El Paso County Parks

Agenda Item Summary Form

Agenda Item Title: Meadowbrook Park Planned Unit Development (PUD) Plan and Preliminary Plan

Development Application Permit Review

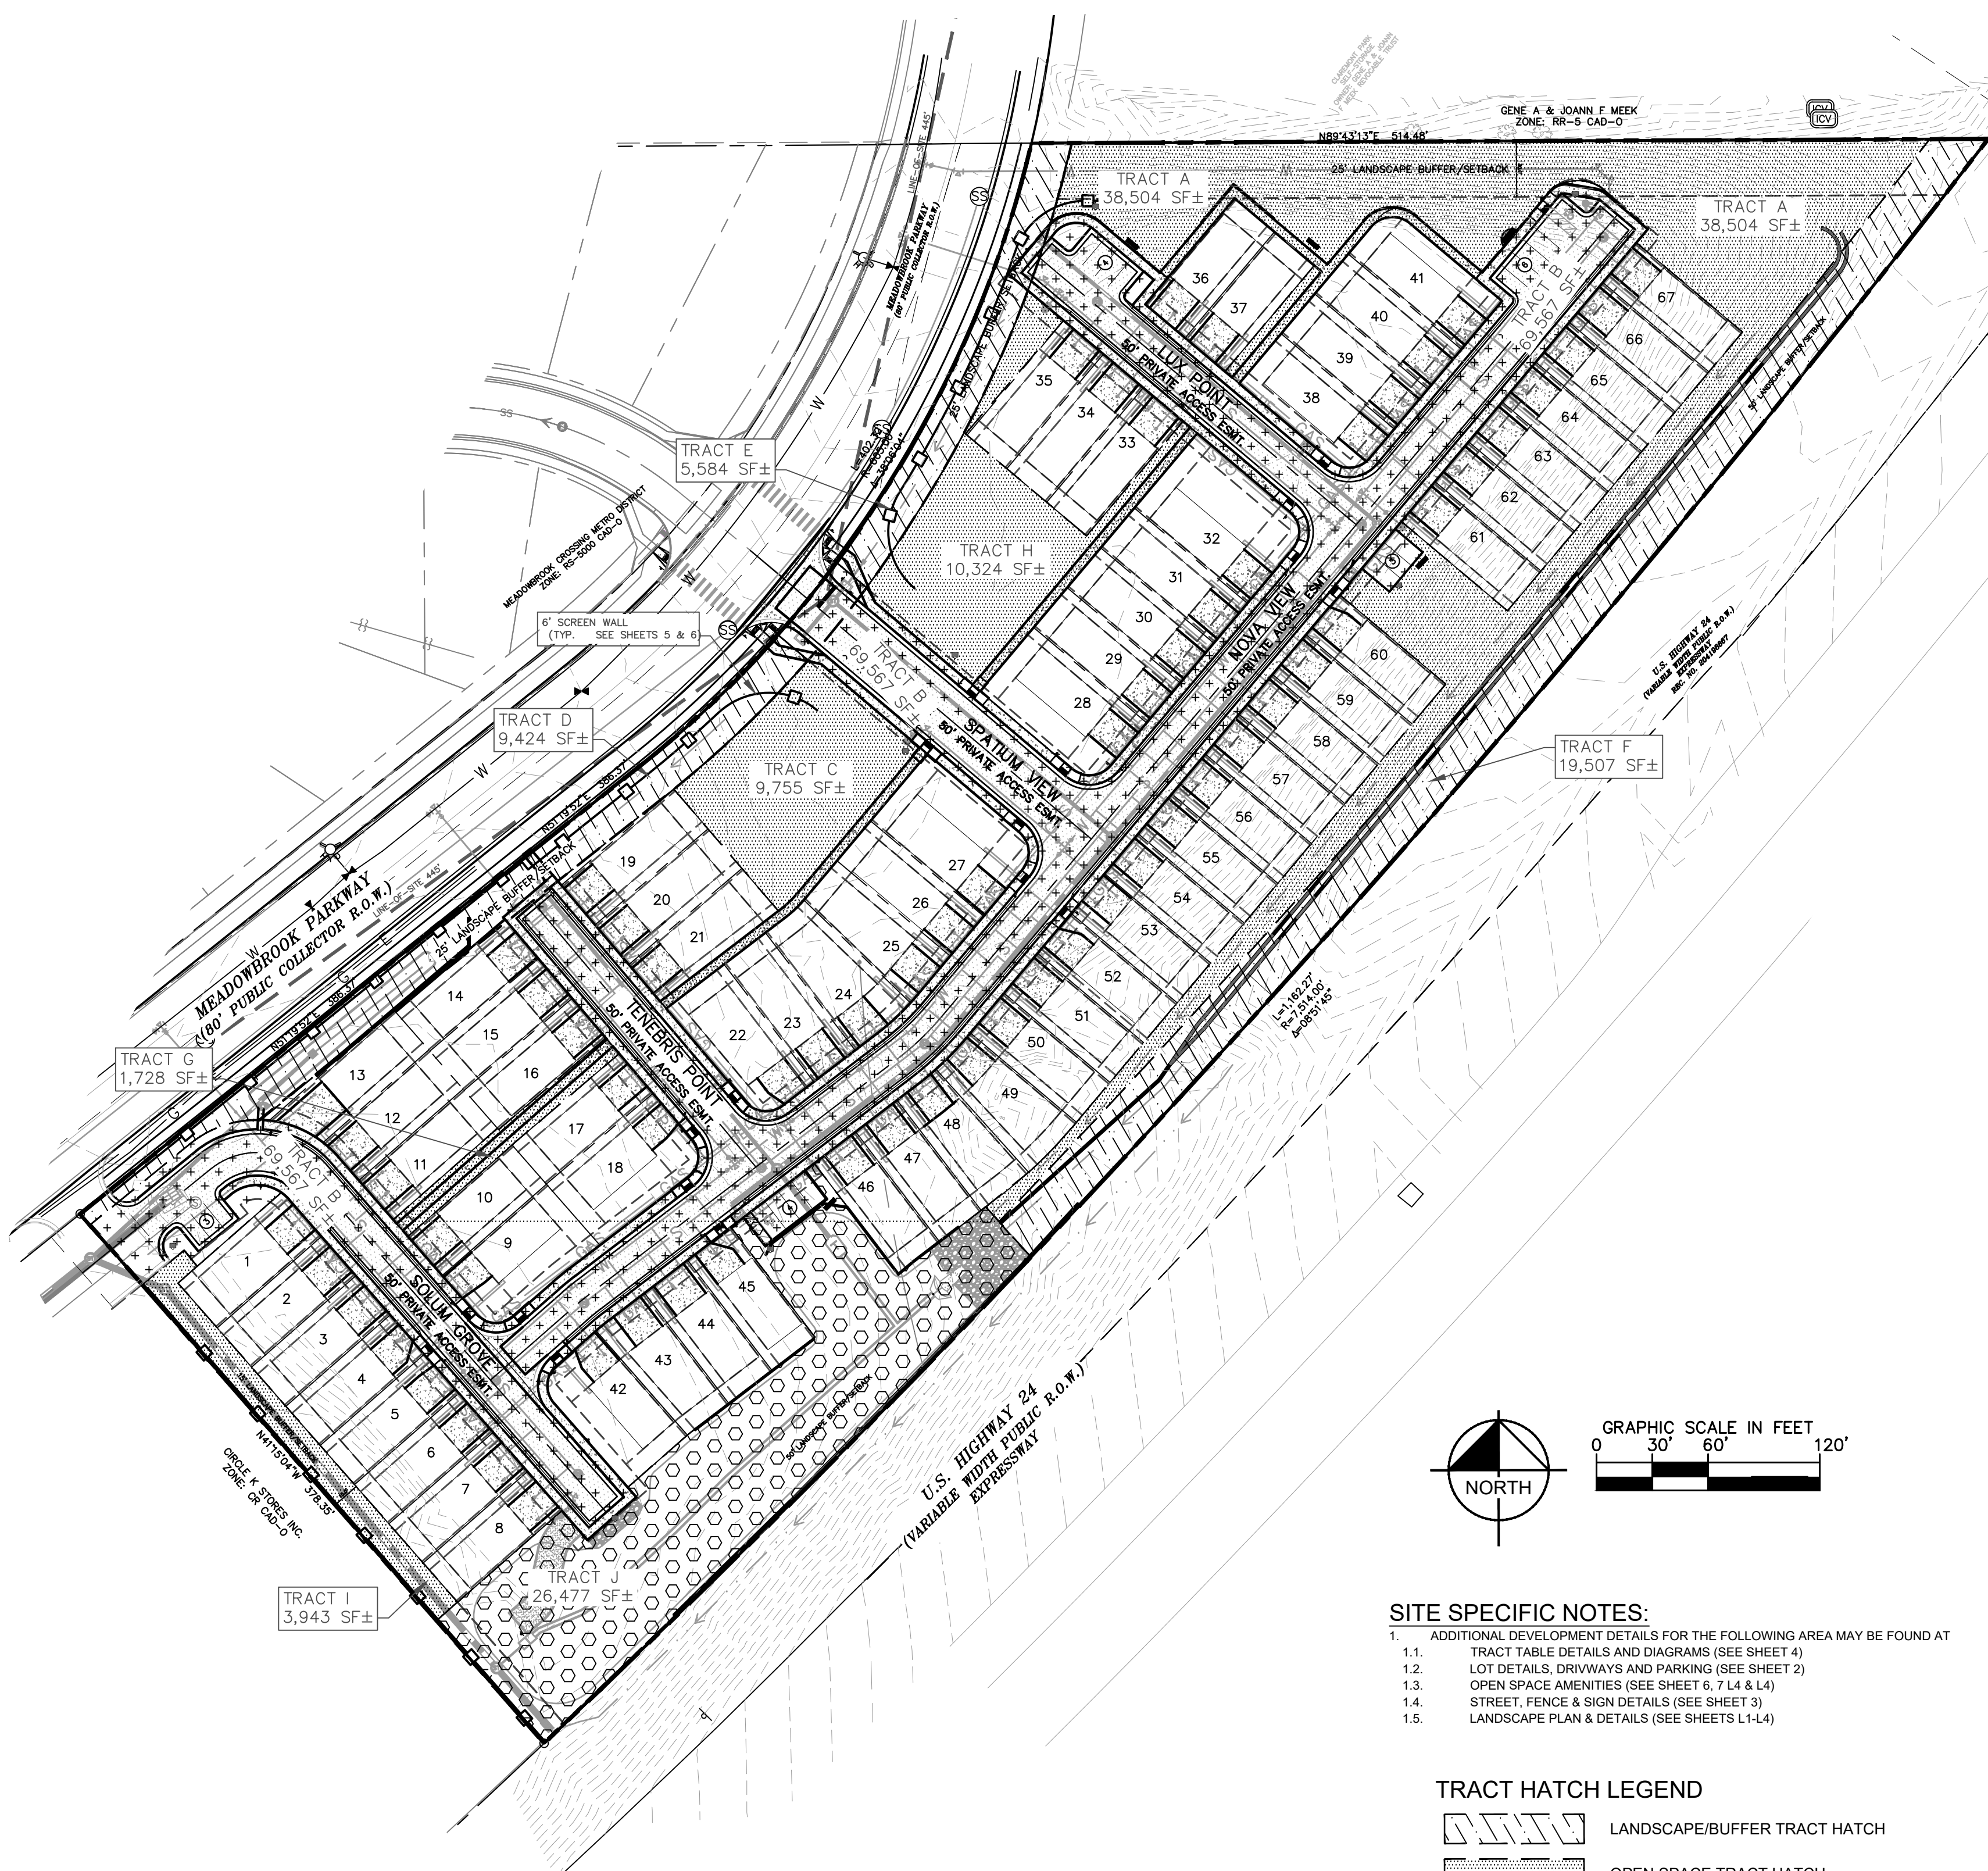
A stormwater detention facility, comprising 0.37 acres, or 19% of the 1.949 acres of open space, occupies a large area in two of the open space tracts, Tracts A and F. The remaining 1.58 acres, or nearly 20% of the overall project area, is located in the remaining sections of Tracts A, C, and G, and is shown to be contiguous and usable. While the inclusion of the stormwater facility in the open space calculations is not allowed under the provisions of the Land Development Code, the removal of the stormwater detention facility acreage does not place the development below the required 10% open space requirement.

As no trail easement or park land dedications are required for this application, staff recommends regional and urban park fees in lieu of land dedication for regional or urban park purposes. Staff additionally recommends that the applicant include descriptions of the two neighborhood pocket parks in the Letter of Intent, as well as more detailed drawings of the parks in the PUD and Preliminary Plans. Lastly, staff requests the removal of the stormwater detention facility from Tract A and the overall open space acreage calculations, with recalculated tract acreages to be reflected in the Letter of Intent and Preliminary Plans.

The Park Advisory Board recommends that the Planning Commission and the Board of County Commissioners include the following conditions when considering and/or approving the Meadowbrook Park Planned Unit Development Plan and Preliminary Plan: 1) per the El Paso County Land Development Code, remove the stormwater detention facility from Tract A and recalculate the open space acreage; 2) include descriptions and drawings of the two neighborhood pocket parks in the Letter of Intent and PUD Plan and Preliminary Plans, respectively; 3) fees in lieu of land dedication for regional park purposes in the amount of \$32,690 and urban park fees in the amount of \$20,650 will be required upon recording of the forthcoming final plat(s). A Park Lands Agreement may be an acceptable alternative to urban park fees, provided the agreement is approved by the County and executed prior to recording the forthcoming final plat(s).
